Subject: RE: Development at Ferringham lane - FG/145/21/DOC

Re: Development at Ferringham lane - FG/145/21/DOC

Engineers Comments Regarding Surface Water Drainage

Drawing Title
**Surface Water Drainage Layout
and Construction Details**

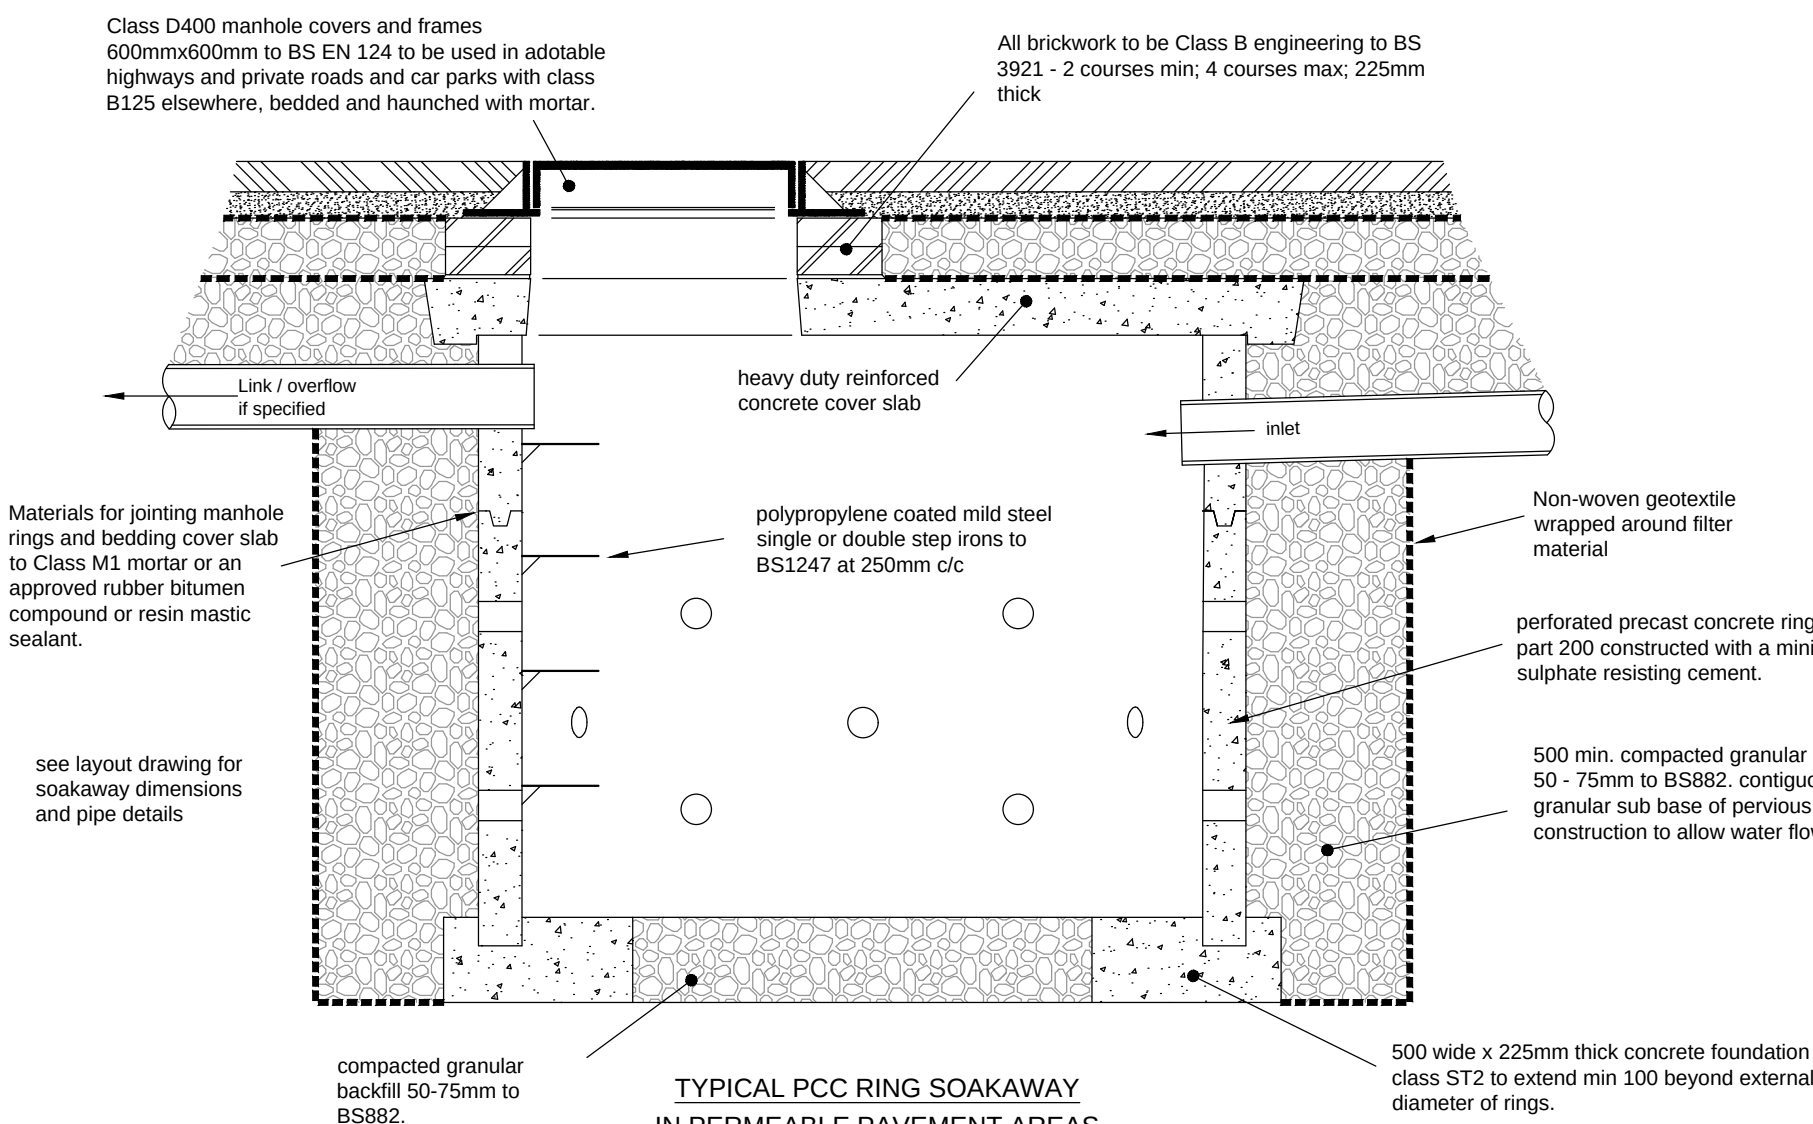
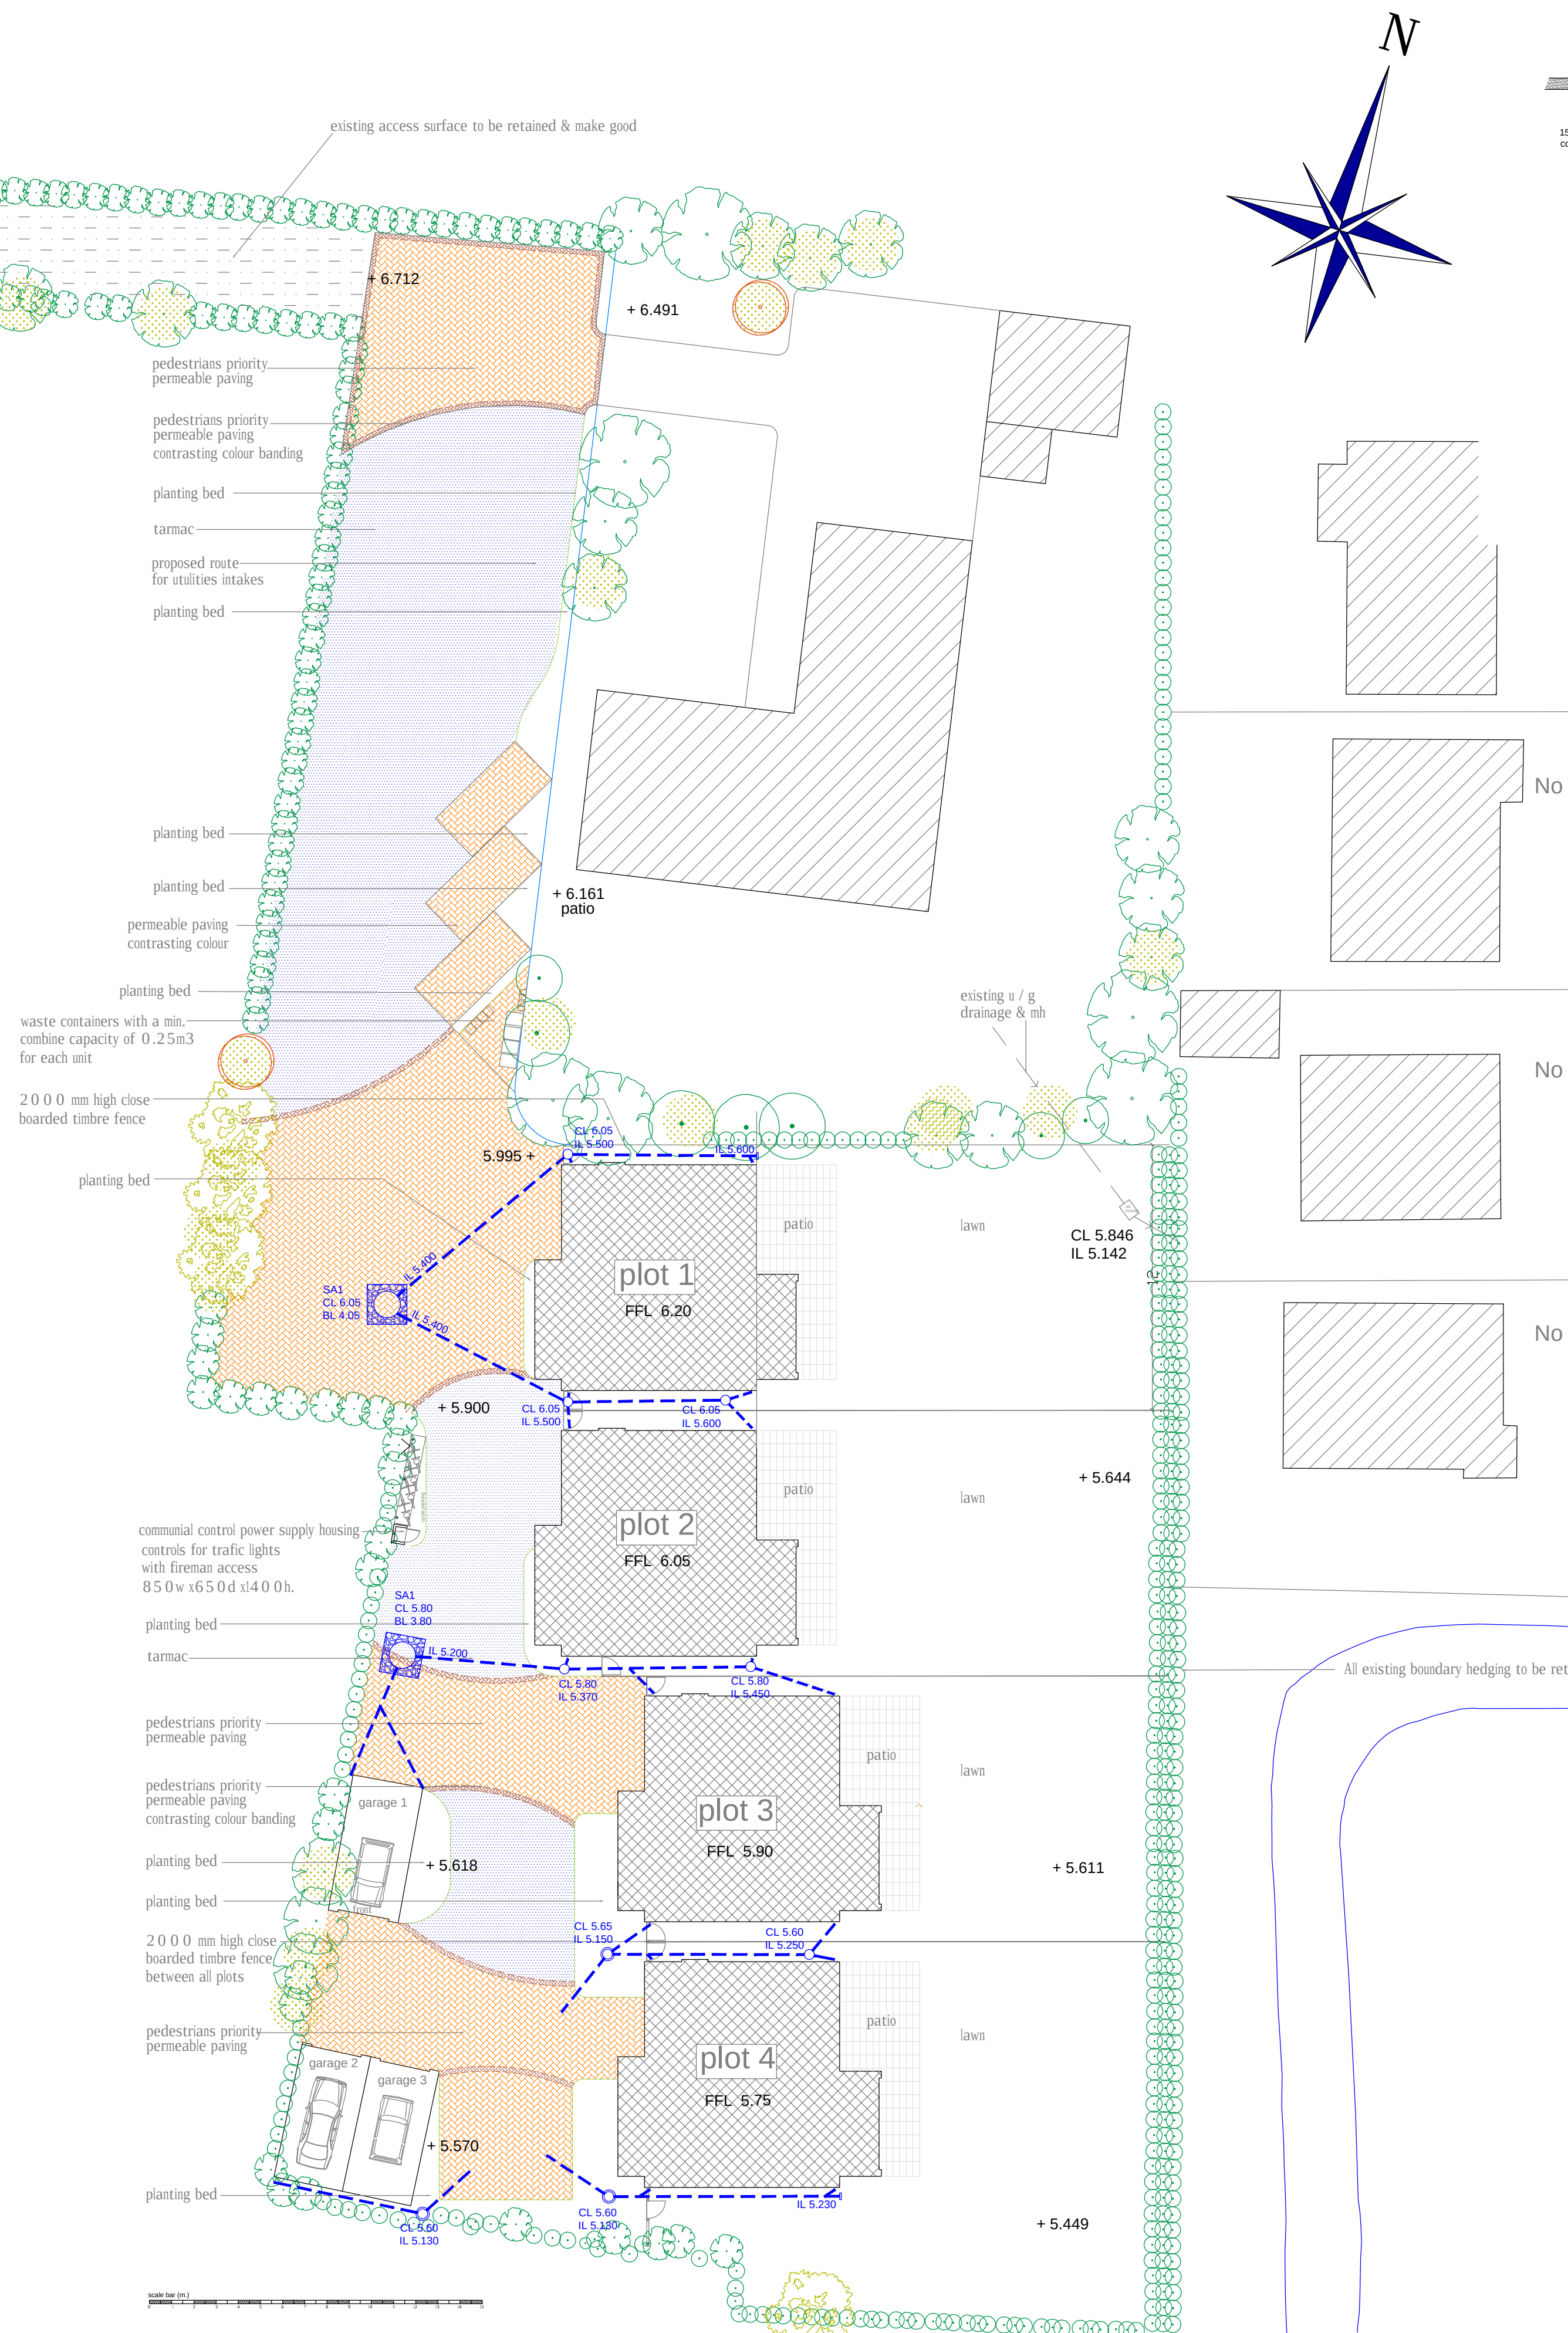
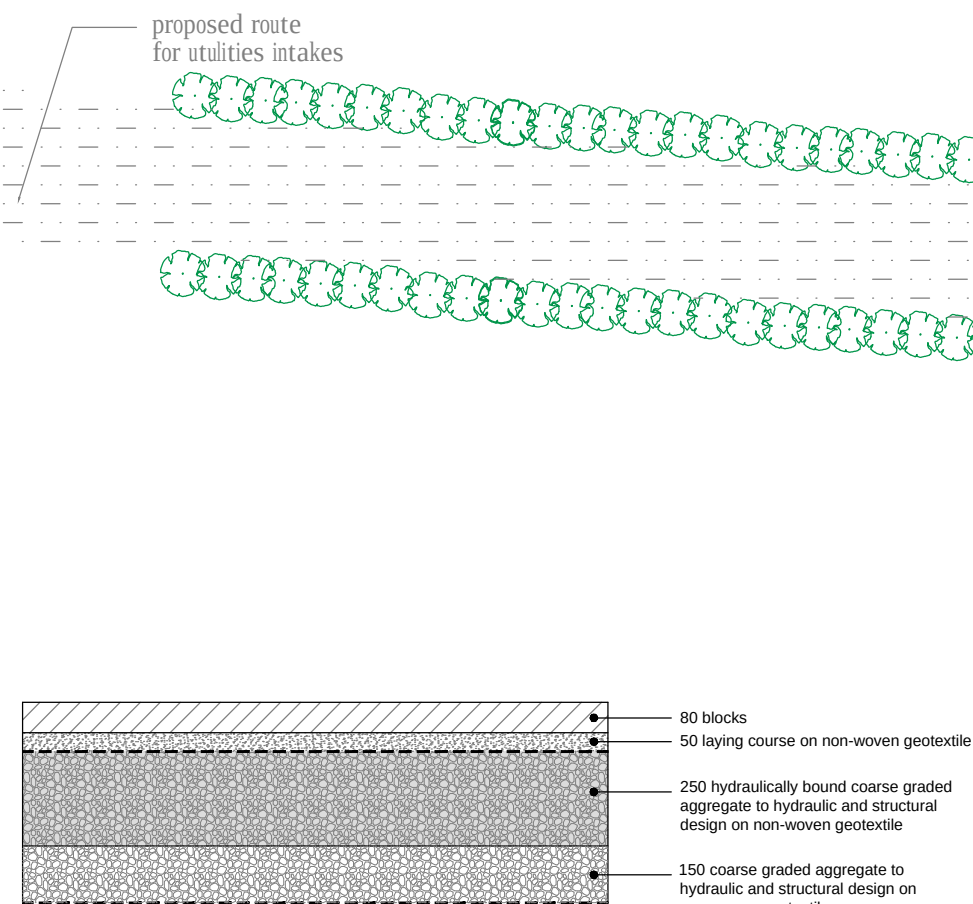
1. *No reference is made on the drainage layout to the groundwater levels evidenced on the site. Just that "Groundwater levels are know [sic] to be high in this area". This was picked up on by Laura Gibbons in her consultation on FG/140/18/DOC on 17/08/2018 (uploaded 21/08/2018) and stated that "discussions have been held with the applicant and their engineer. Winter groundwater monitoring was available from a neighbouring site and this has been used for design". No reference has been made to which site this was or what level groundwater was found at.*

However, I am aware of groundwater levels of 0.37m bgl (below ground level) at 40 Little Paddocks (another neighbouring property - application reference FG/74/20/DOC) which rendered infiltration unsuitable for that site and would indicate that the soakaways proposed for this site are too deep.

Please present alternative groundwater monitoring data (with application references if not for this site) which illustrates that the infiltration depth proposed is appropriate for the site and if the level is significantly different from that evidenced that 40 Little Paddocks please provide a reasonable explanation for this. In my opinion, site specific groundwater monitoring should have been provided for a site of this size and if a satisfactory solution can not be found without an accurate understanding of the site conditions then it will be requested.

2. *I am not satisfied with the timing of the infiltration testing nor the factor of safety used. In this case and only due to the previous approval it will be accepted again, however, this must not be read as precedent set.*

3. *Calculations need to be updated for the increased impermeable area as a result of the non-material amendment. Although the footprint of the buildings has been increased slightly (from 476m² to 490m²) the areas of paving have been reduced. The total area of building and paving has been reduced from 1402m² to 1157m² and the percentage of permeable paving has been increased. Please see attached diagram showing the calculations.*

4. *The Drainage Layout needs to be updated to account for the updated layout. Please pay attention to Note 10 on our Drainage Checklist [download.cfm \(arun.gov.uk\)](https://www.arun.gov.uk/download.cfm) for the level of detail required on the layout as this will have changed since the previous approval in 2018. I have attached my revised site plan 20-07-3.17*

5. *Please provide construction detail drawings for all components. Again this requirement is listed in the drainage checklist linked above (under Note 11).* On the attached revised site plan 20-07-3.17 Revision E, I have added construction details as shown on the layout previously approved.

I've attached groundwater monitoring data that was submitted with the previously approved application FG/140/18/DOC.

Revision E, on which I have added additional information. I have also omitted the additional soakaways shown in the rear gardens

Groundwater Monitoring at Development Site @ #1 Beehive Lane Ferring

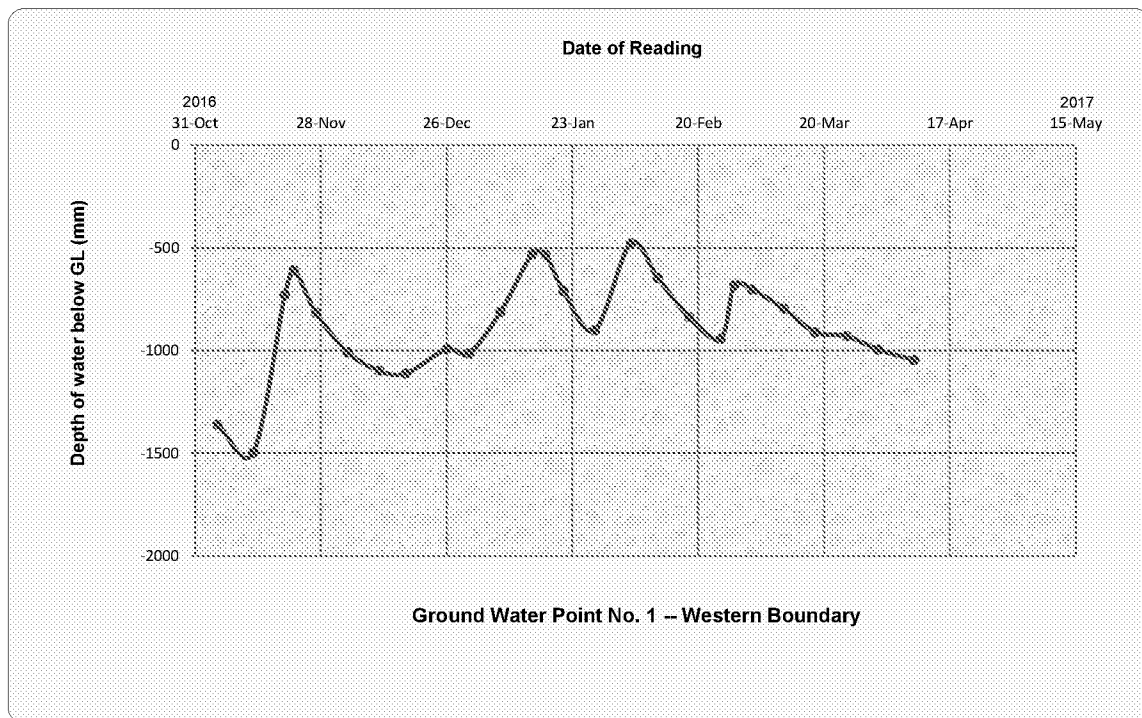
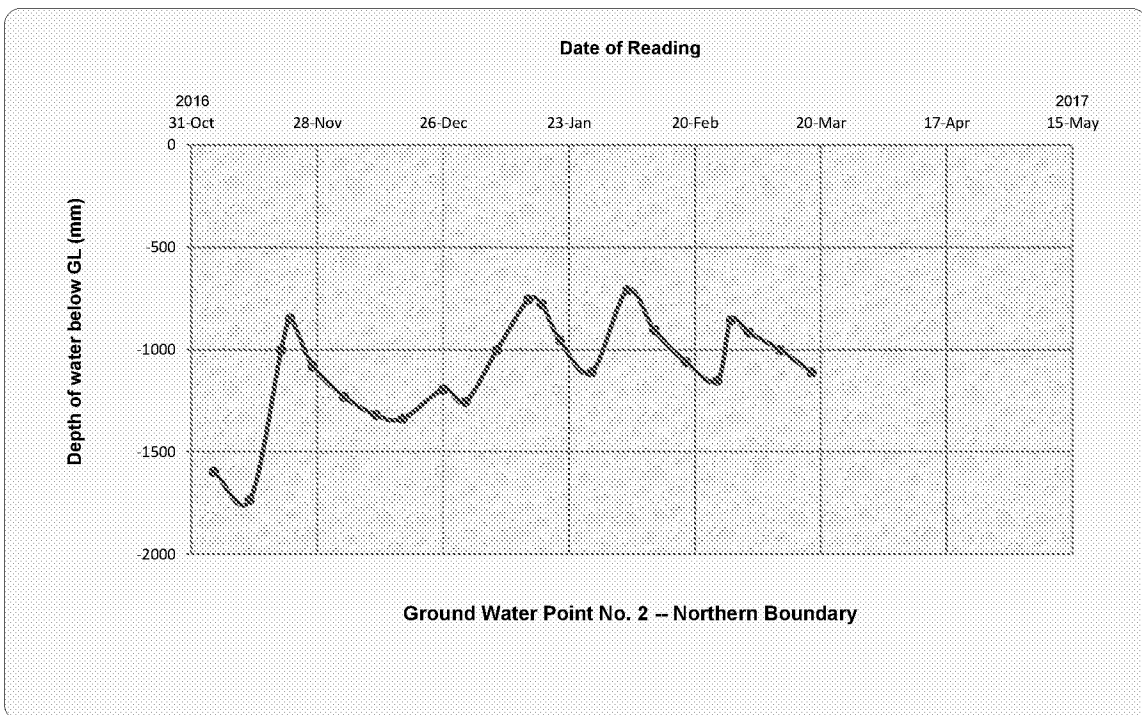
I have taken a look at the groundwater monitoring you have supplied (from 1 Beehive Lane) and unfortunately this is located further from the proposed development than the data that I referenced at 40 Little Paddocks (below). On this basis I will not be prepared to accept it to justify the surface water drainage design for the site.

I suggest that groundwater monitoring is undertaken on the site from early December to late February to capture accurate site specific data that can be utilised for the purposes of the design.
